May 24, 2024

**Re: Universe View Subdivision Site Plan for Commercial Development DFT Comment
Response
Zone Atlas D-10; COA Project # PR-2020-004596; SI-2024-00390**

On behalf of Mr. and Mrs. Rabadi, Huitt-Zollars, Inc. is submitting responses to DFT comments from the May 1, 2024 hearing and requests review of the attached submittal for the Universe View Subdivision Commercial Development with address/location: Lot 1, Block A, Unit 17, located at the southeast corner of Universe Blvd NW & Rosa Parks Rd NW, consisting of approximately 2.936 acres zoned MX-L. All DFT comments have been addressed below. Please note that DFT comments are in *italics* and our responses are in **bold** text.

Sheet Number:  
**LS-01**

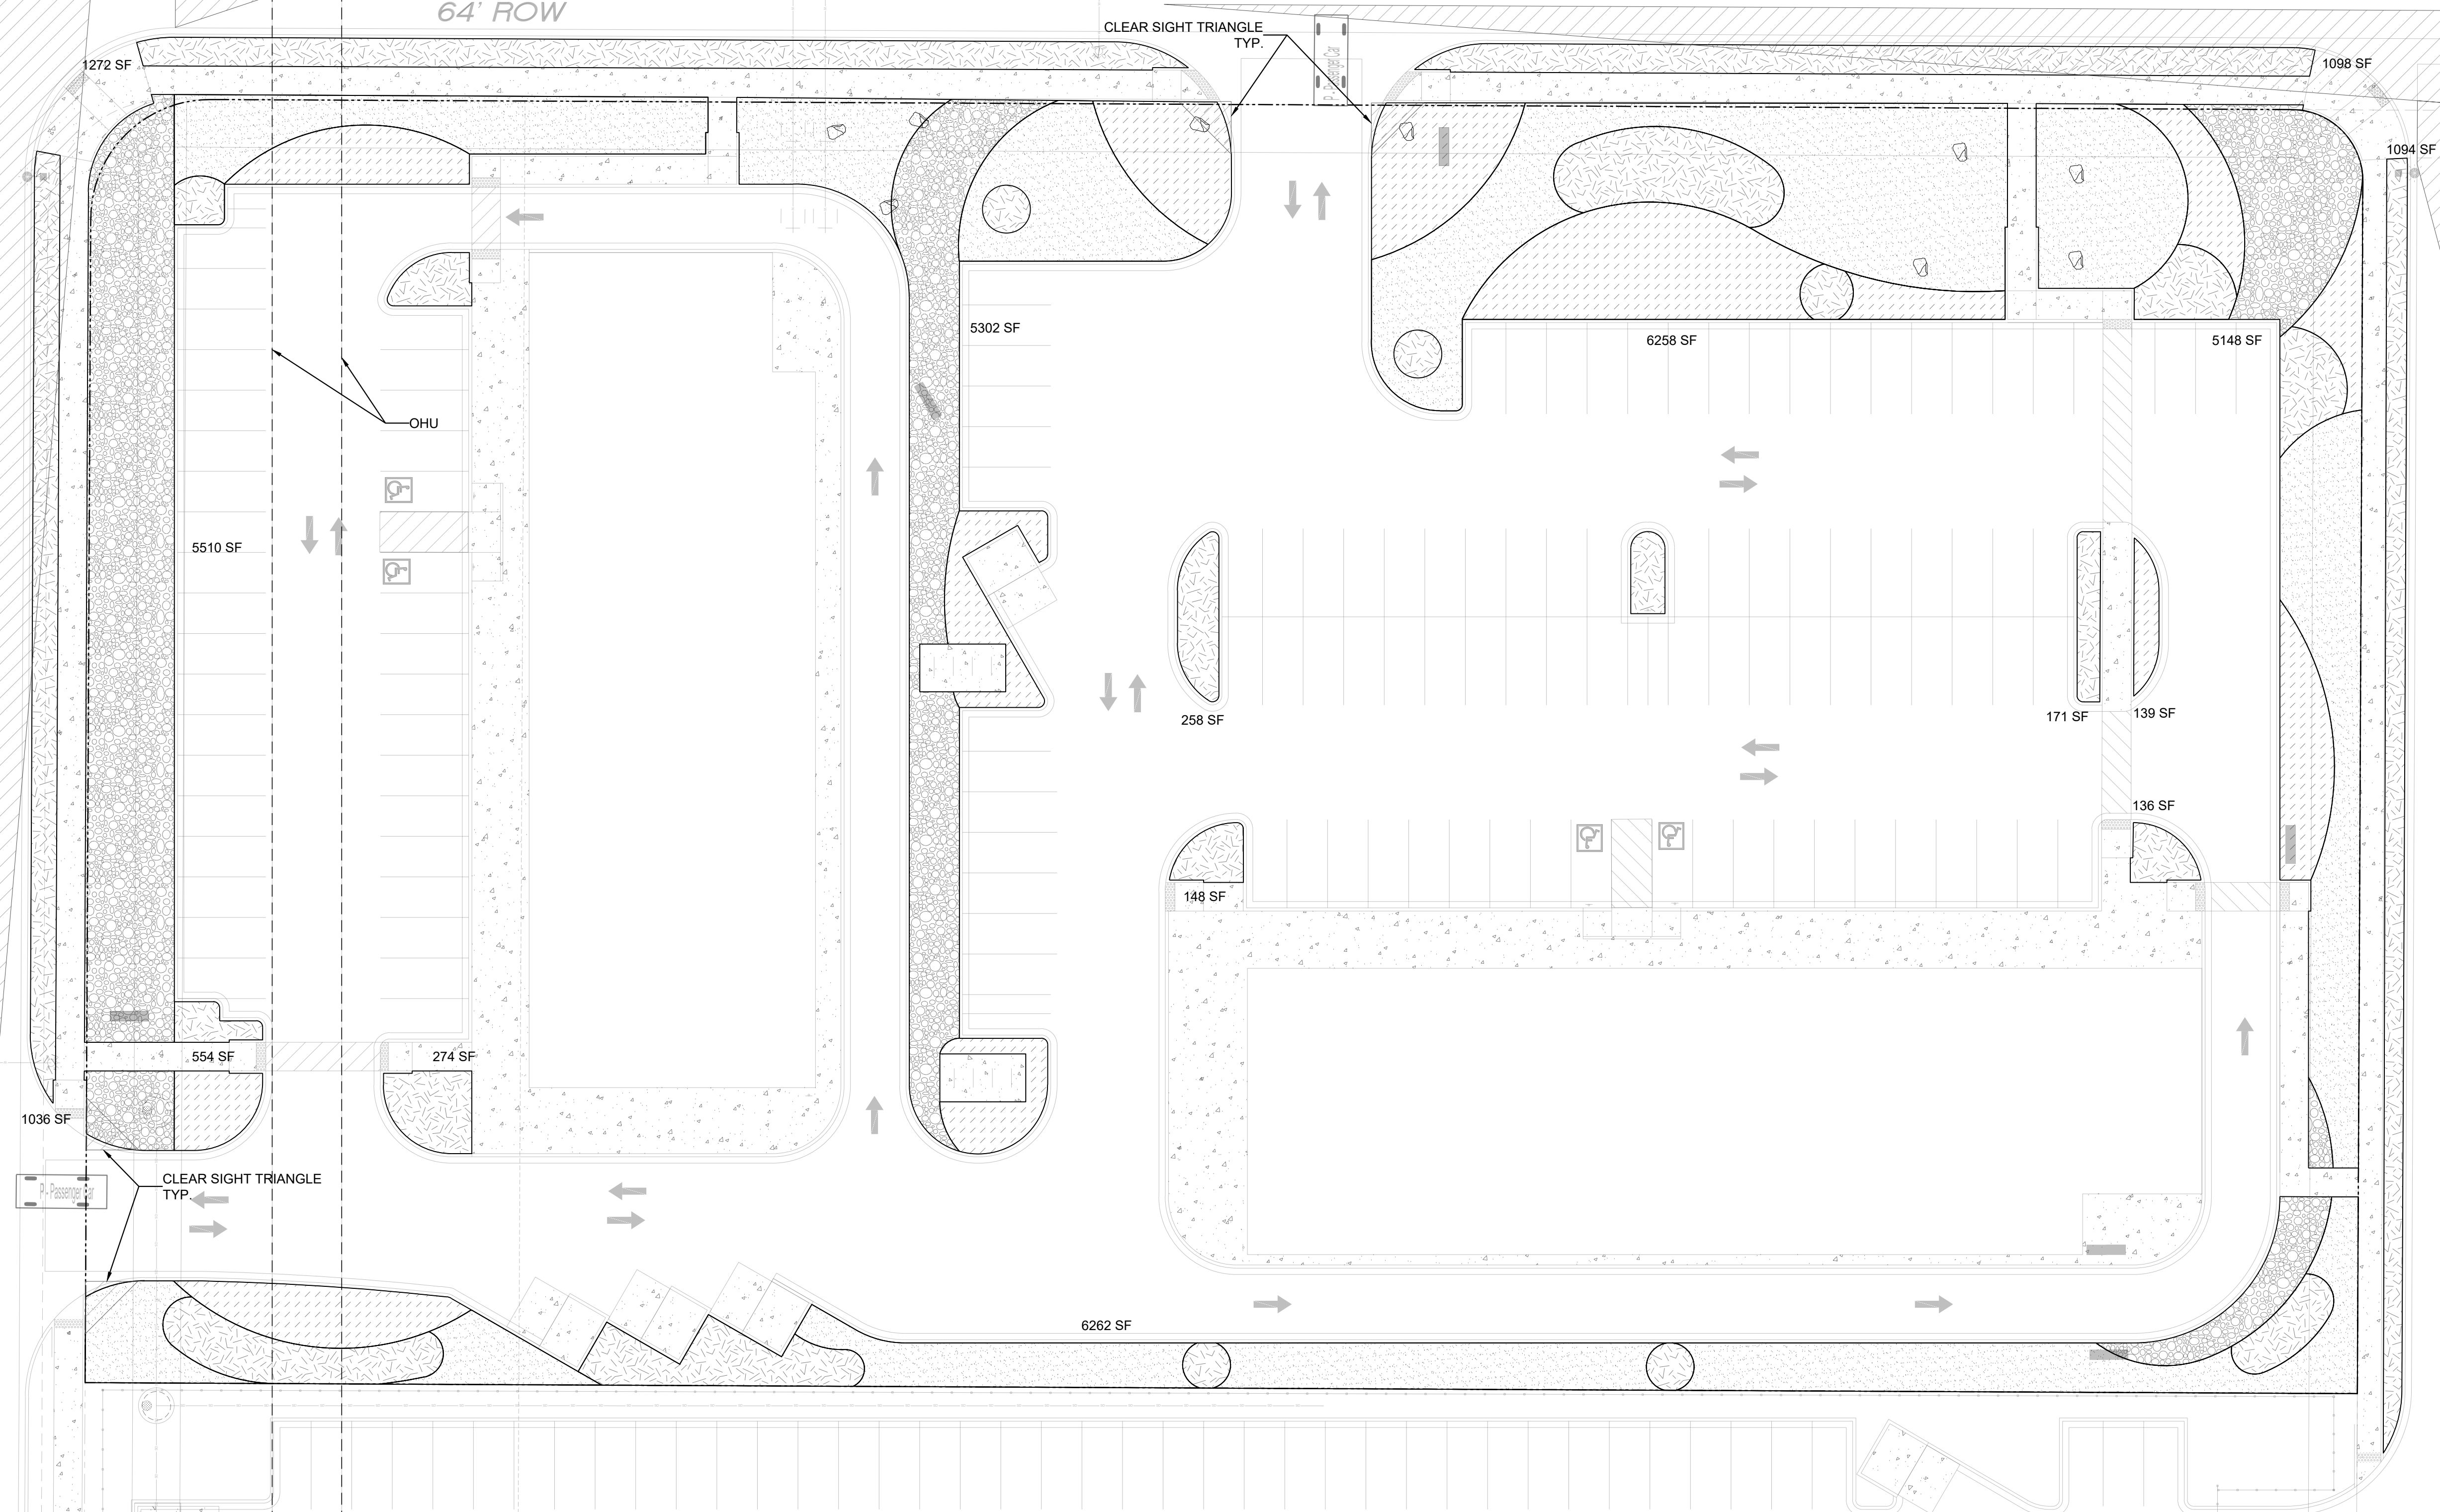
2. *Submit an updated landscaping plan that matches the Site Plan. Include all relevant detail for each requirement within section 5-6. Including but not limited to 5-6-C General Landscaping, 5-6-C-2 Minimum Landscape Area, 5-6-D Required Street Trees, 5-6-E-2 Development next to Low Density Residential, 5-6-F Parking Lot Landscaping, 5-6-G Equipment/Support areas.*

Landscape Plan has been updated with latest site plan.

**SITE PLAN**  
SCALE: 1" = 40'-0"

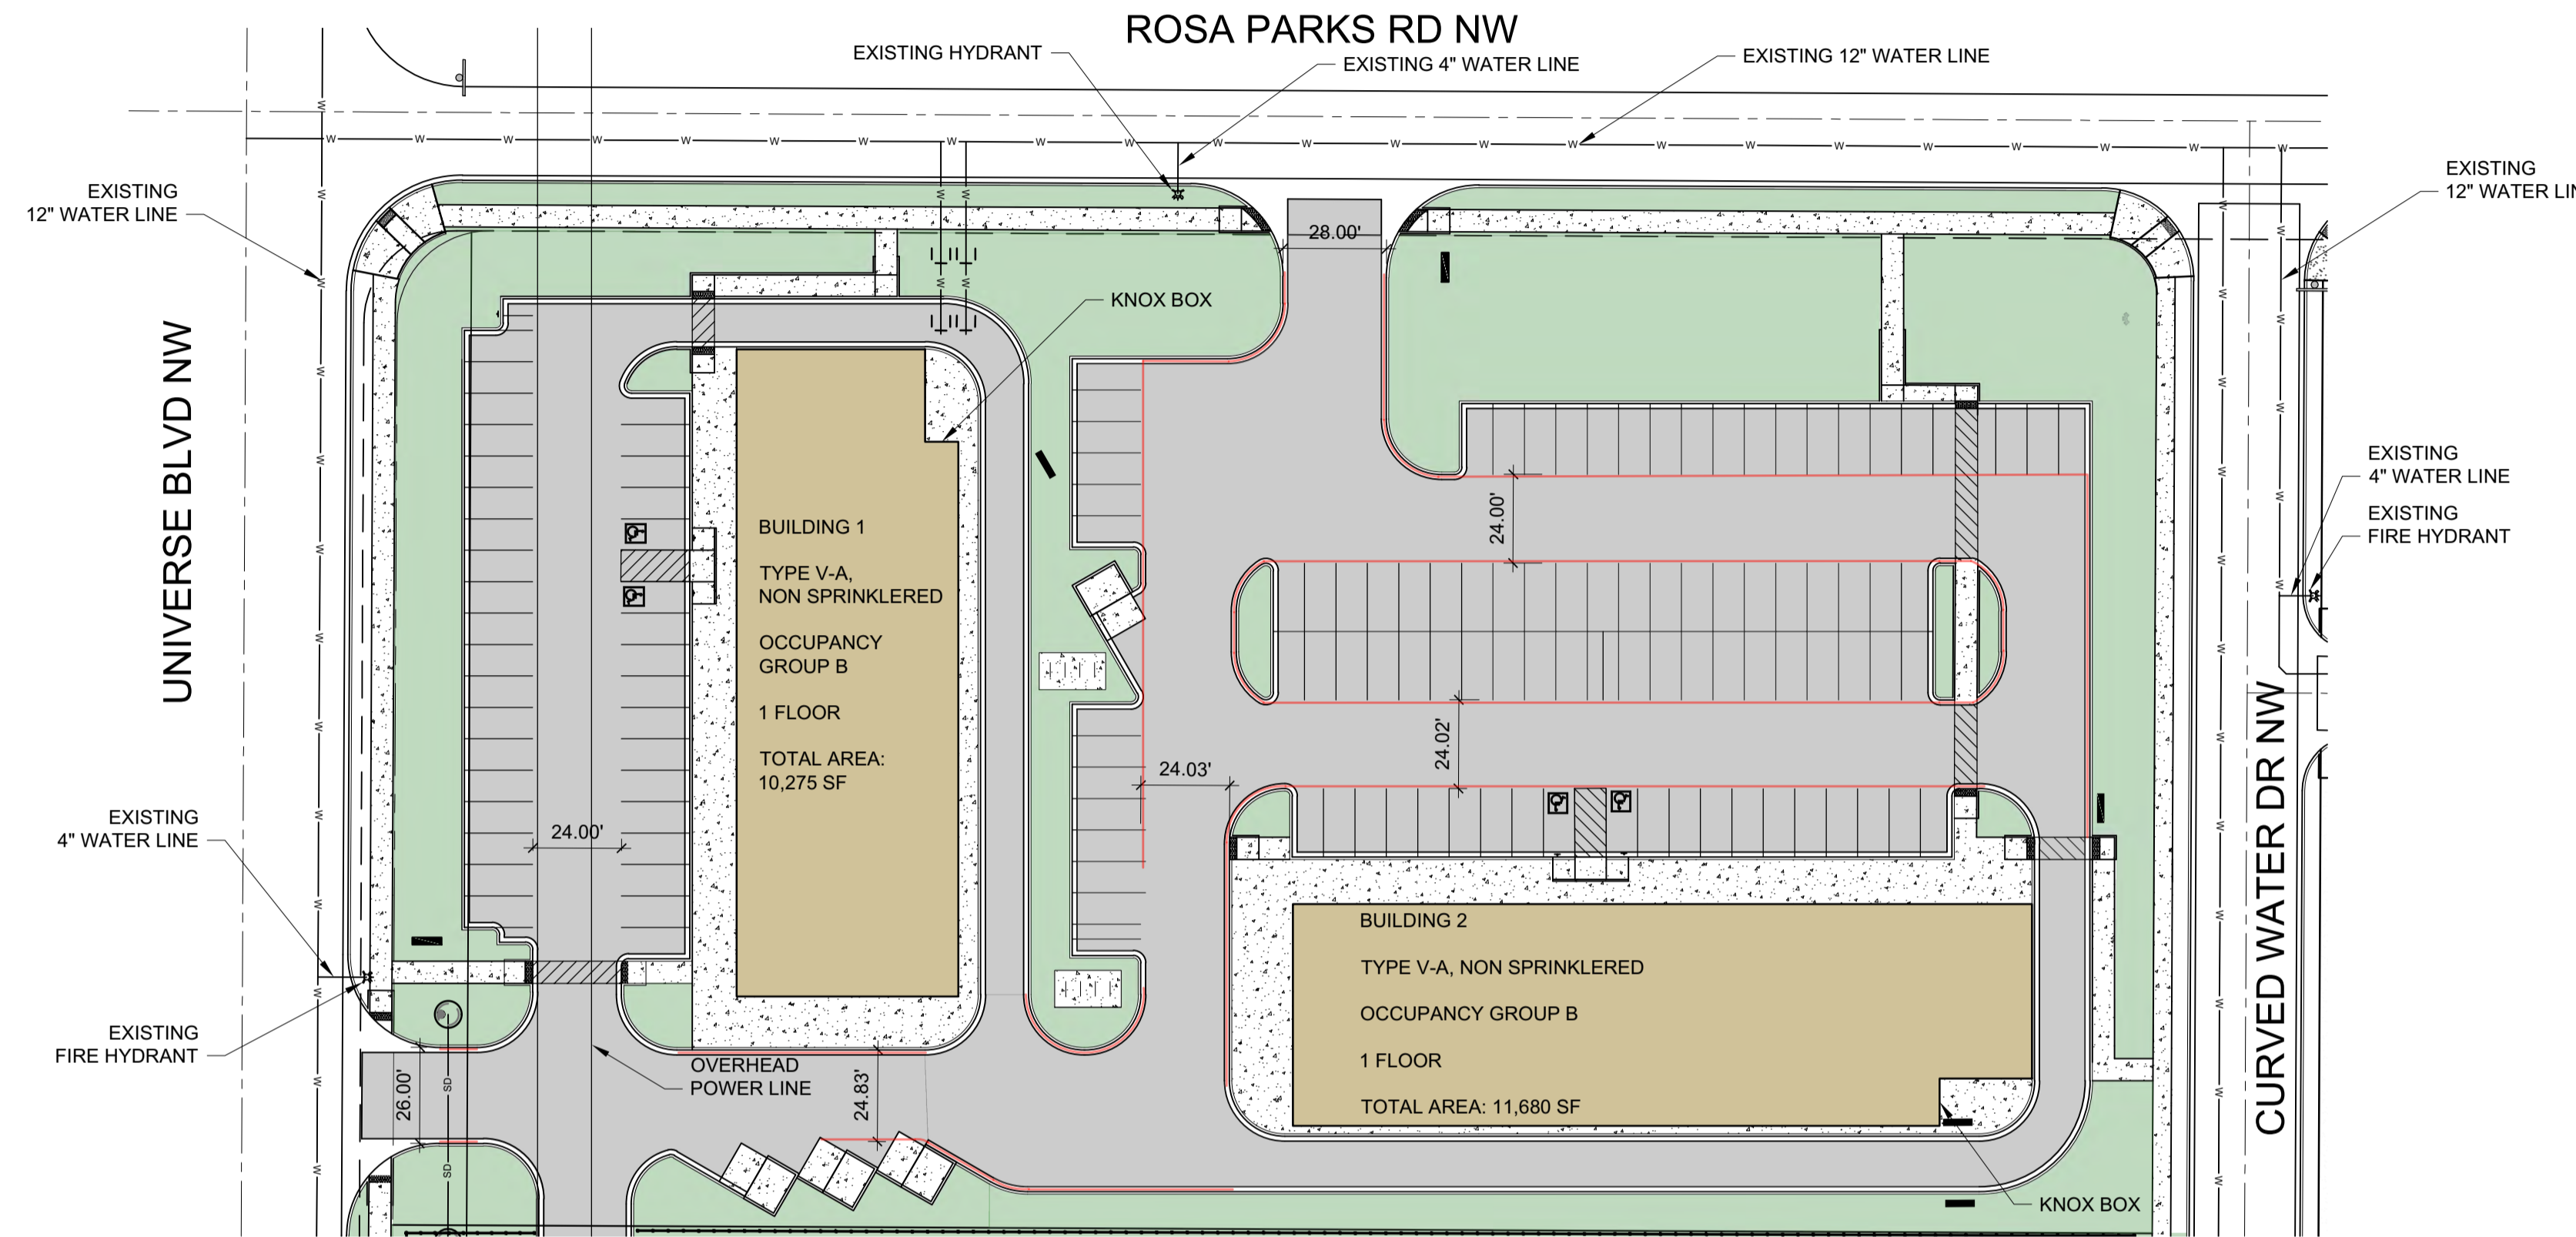
2. *Please show distance from Monument sign to property line, or note on site plan.*

Dimension has been added to the Site Plan.

6. *Demonstrate how Use Specific Standards for Drive-Through are being met. 4-3-F-5 and 5-5-1.*

4-3(F)(5)(a) – Order board for the east building faces south toward the apartment complex, so does not face a public street. The order board for the west building faces east, with public right-of-way more than 300-feet away. There are 2 landscape buffers between the order board and the public street with many trees and shrubs providing screening.

4-3(F)(5)(b) – The site plan complies with 14-16-5-5 (Parking and Loading) and 14-16-5-9 (Neighborhood Edges).

4-3(F)(5)(c) - Noted. Drive-throughs will not be used for cannabis retail. Note added to site plan “DRIVE THROUGH USES SHALL BE LIMITED TO THOSE PERMISSIBLE IN THE IDO”.

5-5(1)(2)(b) – Audible electronic device for west building is about 60-feet away from nearest property line, while it is 30-feet away from nearest property line for the east building. Speakers will not be heard past the property lines. There is a preview board without a speaker nearest property line on the SE corner of the site (south of building 2). The order window is noted by keyed note 28 and is 84ft west of the residential zoned lots to on Curved Water Dr NW and 79ft north of the apartment lot.

5-5(1)(2)(f) – Drive-through service window and order boards are located 50-foot minimum from the apartment lot to the south. The drive through window is 79 ft from the apartment lot. There is no order board for building 2.

5-5(1)(2)(g) – There is a minimum of 15-feet of landscape buffer between the drive-through lane and the apartment complex parking to the south, with a 6-foot high wrought iron fence.
